Client: **ANN DENNING**
 Project: **DENNING RESIDENCE**

FOUNDATION PLAN 1ST FLOOR FRAMING

Project #: 1901-010273
 Date: 01/31/20
 Drawn/Design By: IJE
 DWG. Checked By: PSE
 Scale: SEE PLAN

Sheet Number
S1
 4 of 6

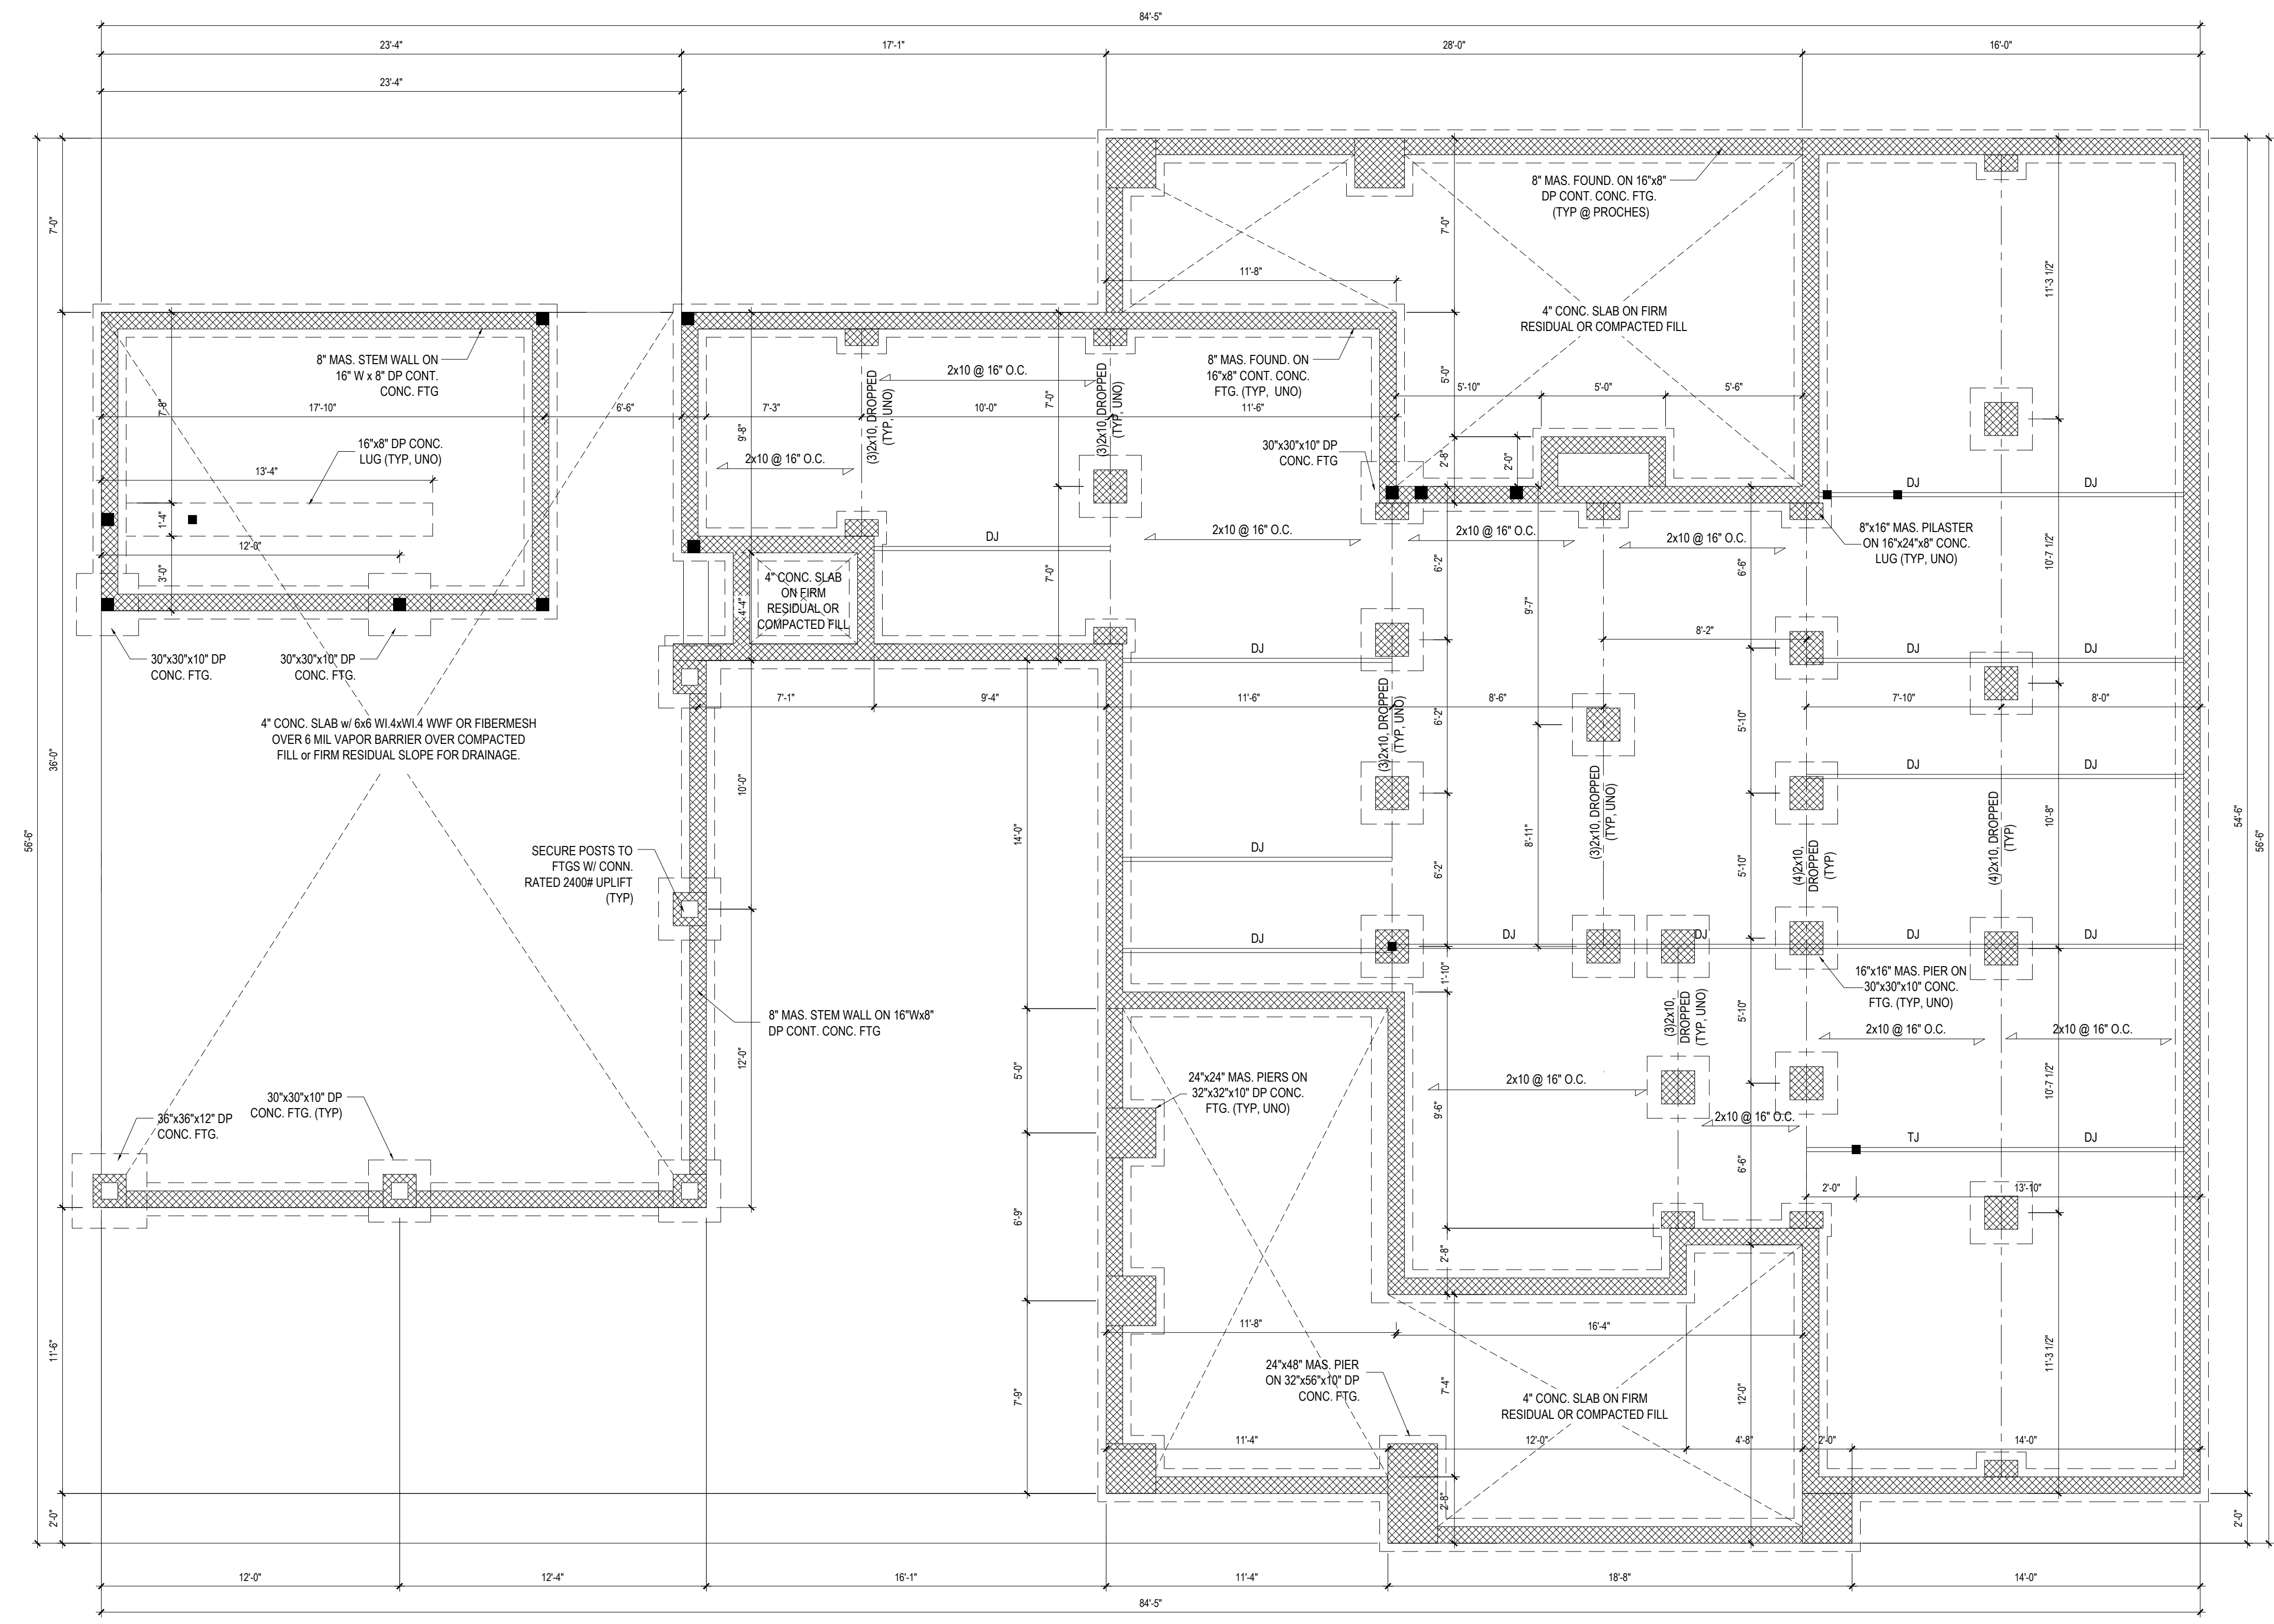
Changed to stemwall. See new foundation drawing
